**From:** [Mike Flory](#)  
**To:** [Kelly Bacon \(CD\)](#)  
**Subject:** RE: VA-20-00001 Brown - Notice of Application  
**Date:** Monday, June 15, 2020 11:04:13 AM

**Subject:** VA-20-00001 Brown - Notice of Application

CDS is requesting comment on the following Setback Variance application VA-20-00001 Brown.

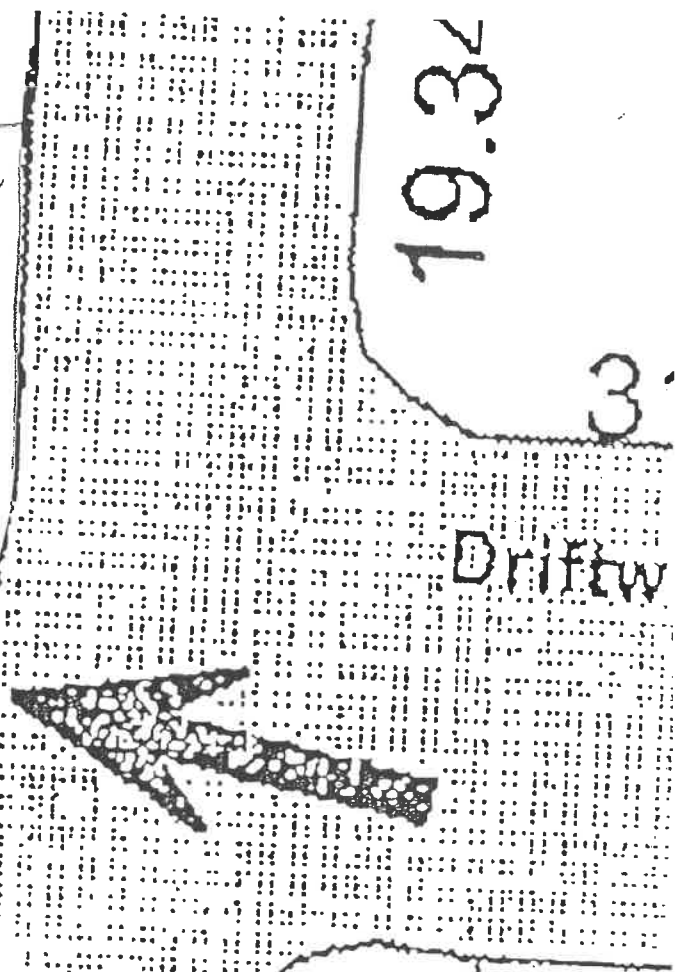
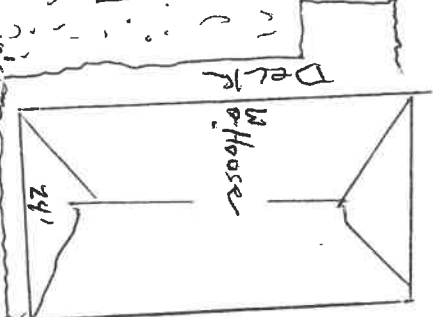
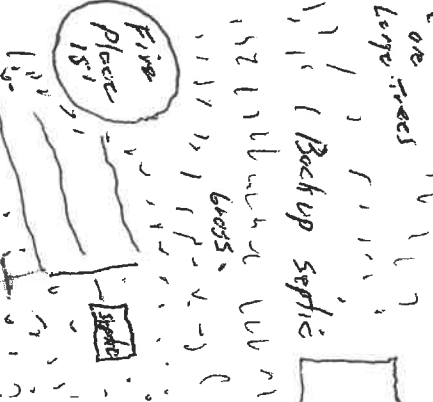
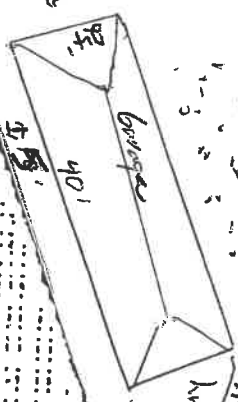
Building Division has no issues with a variance as long as setbacks to property line is a minimum of 5 feet for fire protection.
